# Rezoning Transportation Analysis

Petition Number: 2021-168

## Revision Log:

Date	Description
11-19-2021	First Review (KP)
12-20-2021	Second Review (KP)

RZ1.0

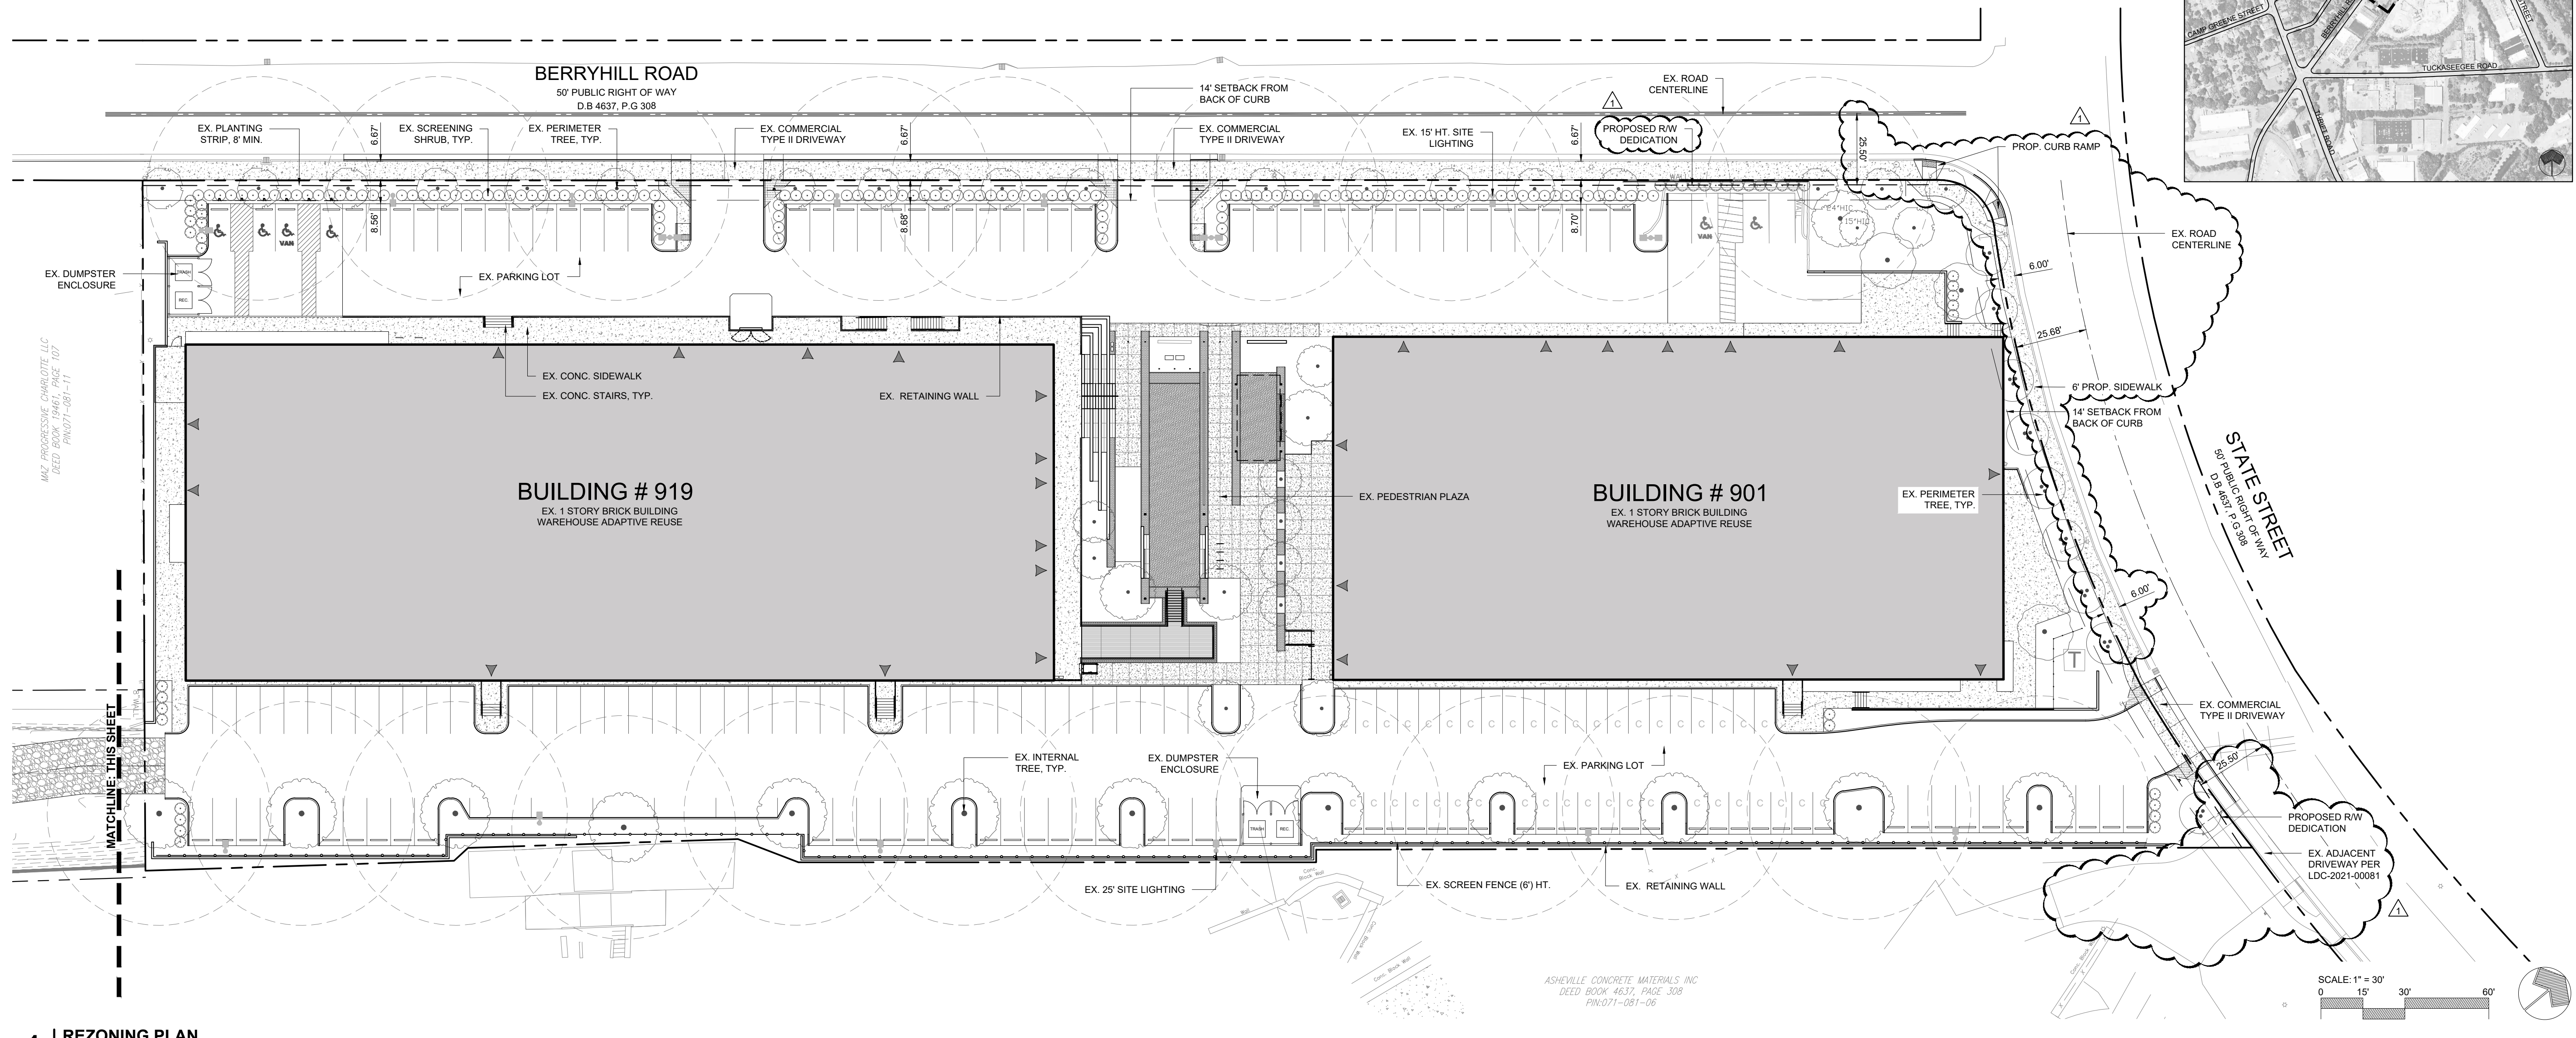
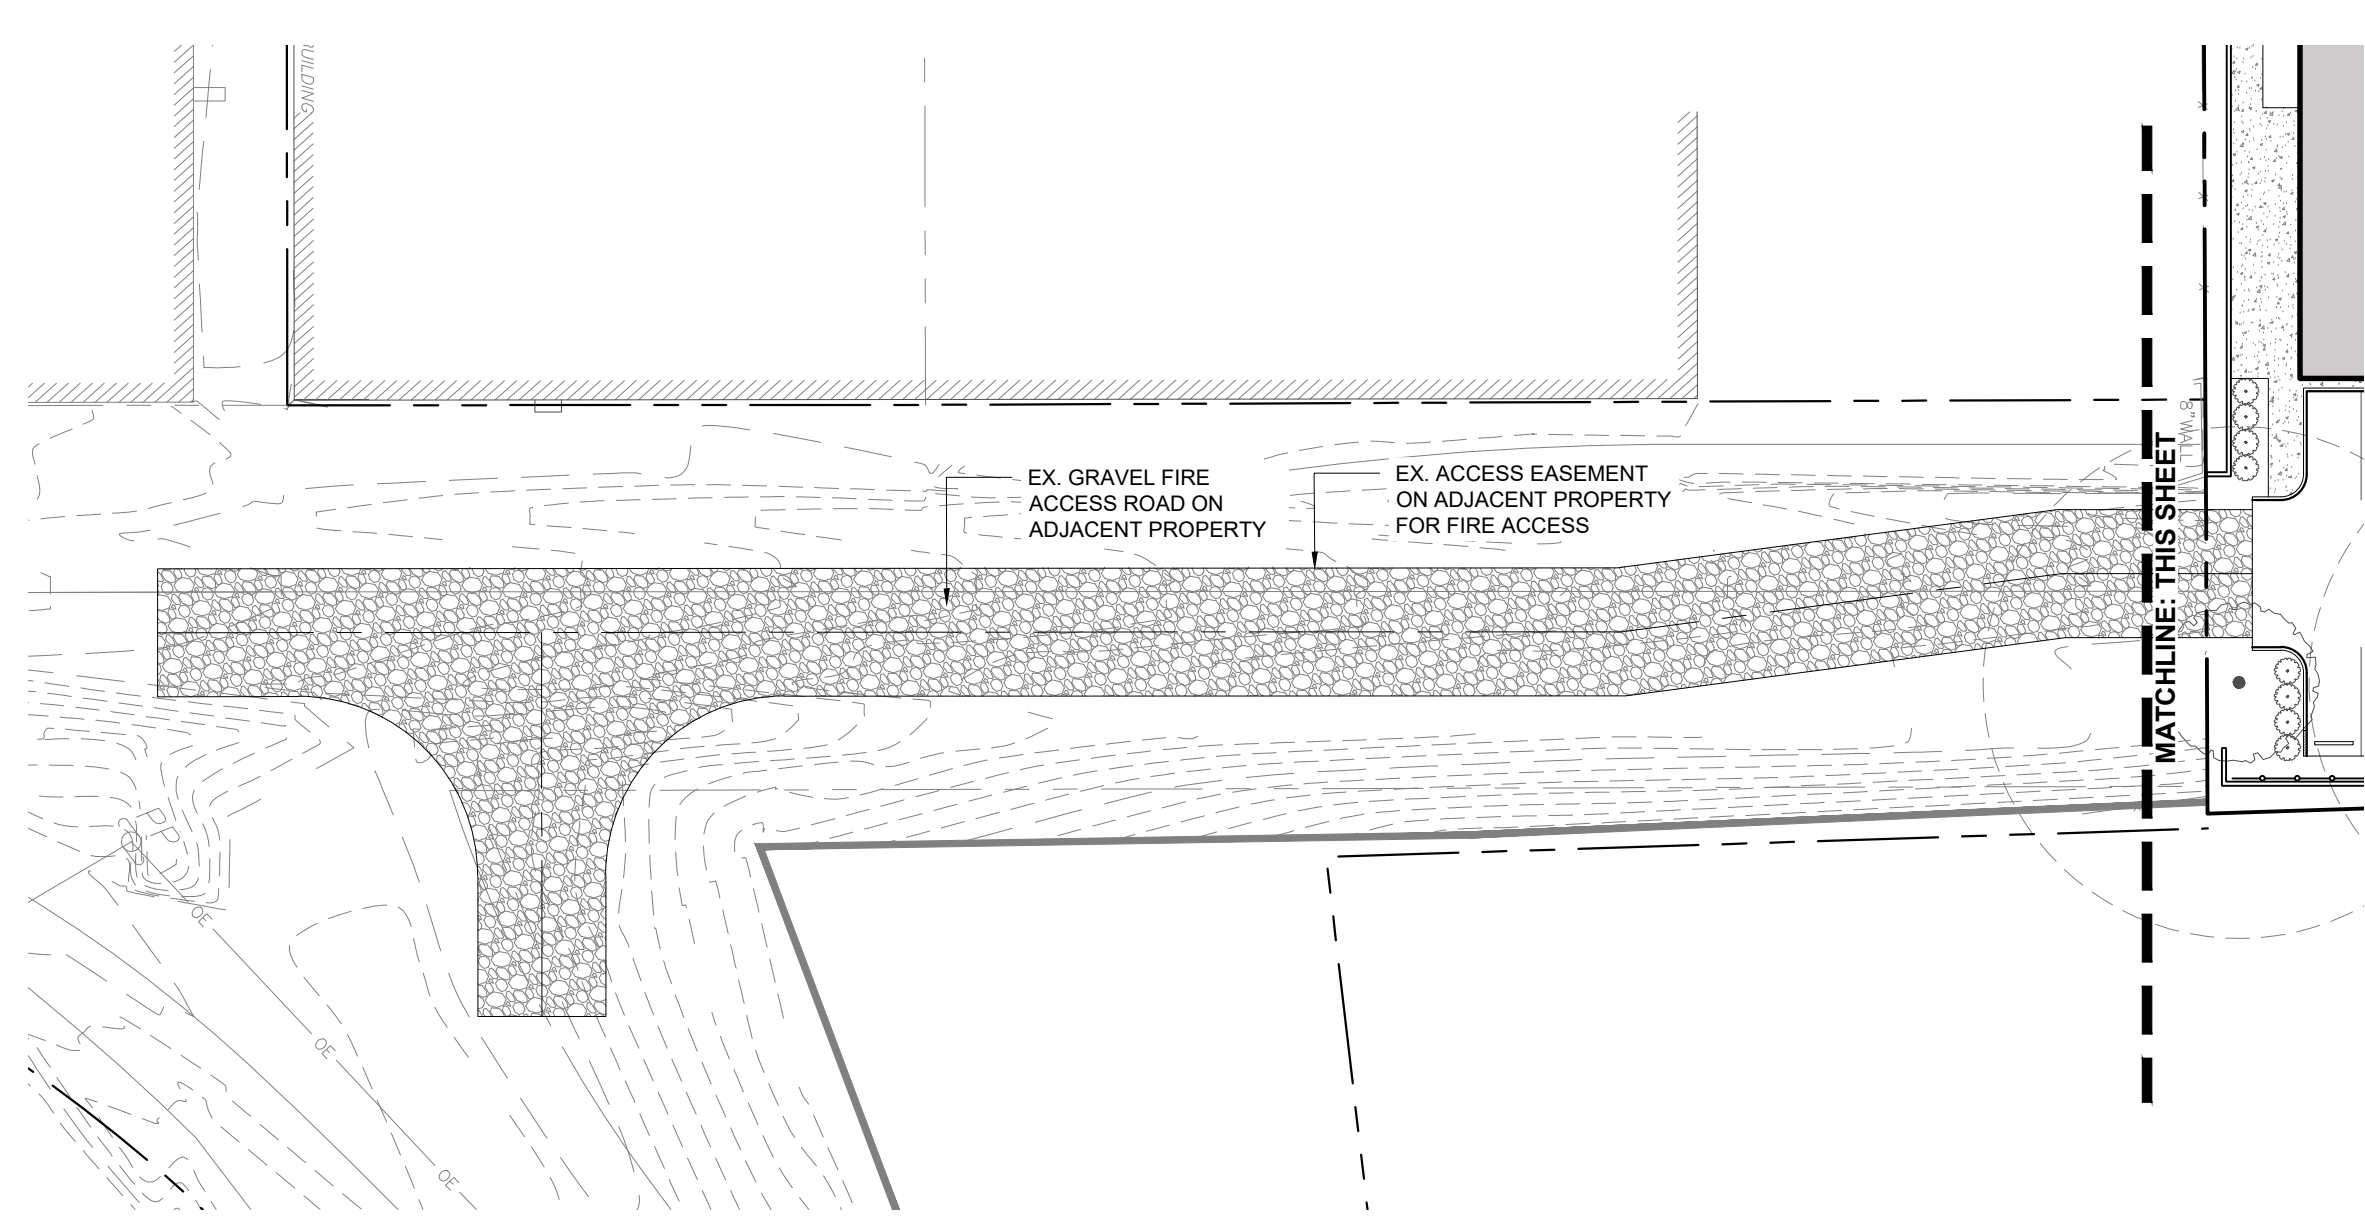
1. **Curb line:** The proposed zoning district has a setback measured from back of the existing or proposed future curb line.
  - a. **Berryhill Road:** In accordance with CLDSM U-07 (Local Collector Street), the future location of back-of-curb and gutter will be 17.5-feet from the existing centerline, however, due to site constraints, the curb and gutter may remain in its existing location.
  - b. **State Street:** In accordance with CLDSM U-07 (Local Collector Street), the future location of back-of-curb and gutter will be 17.5-feet from the existing centerline, however, due to site constraints, the curb and gutter may remain in its existing location.

**Outstanding Comment from 11-19-2021:** Label and dimension the existing and future back-of-curb and gutter from the existing centerline of each road.
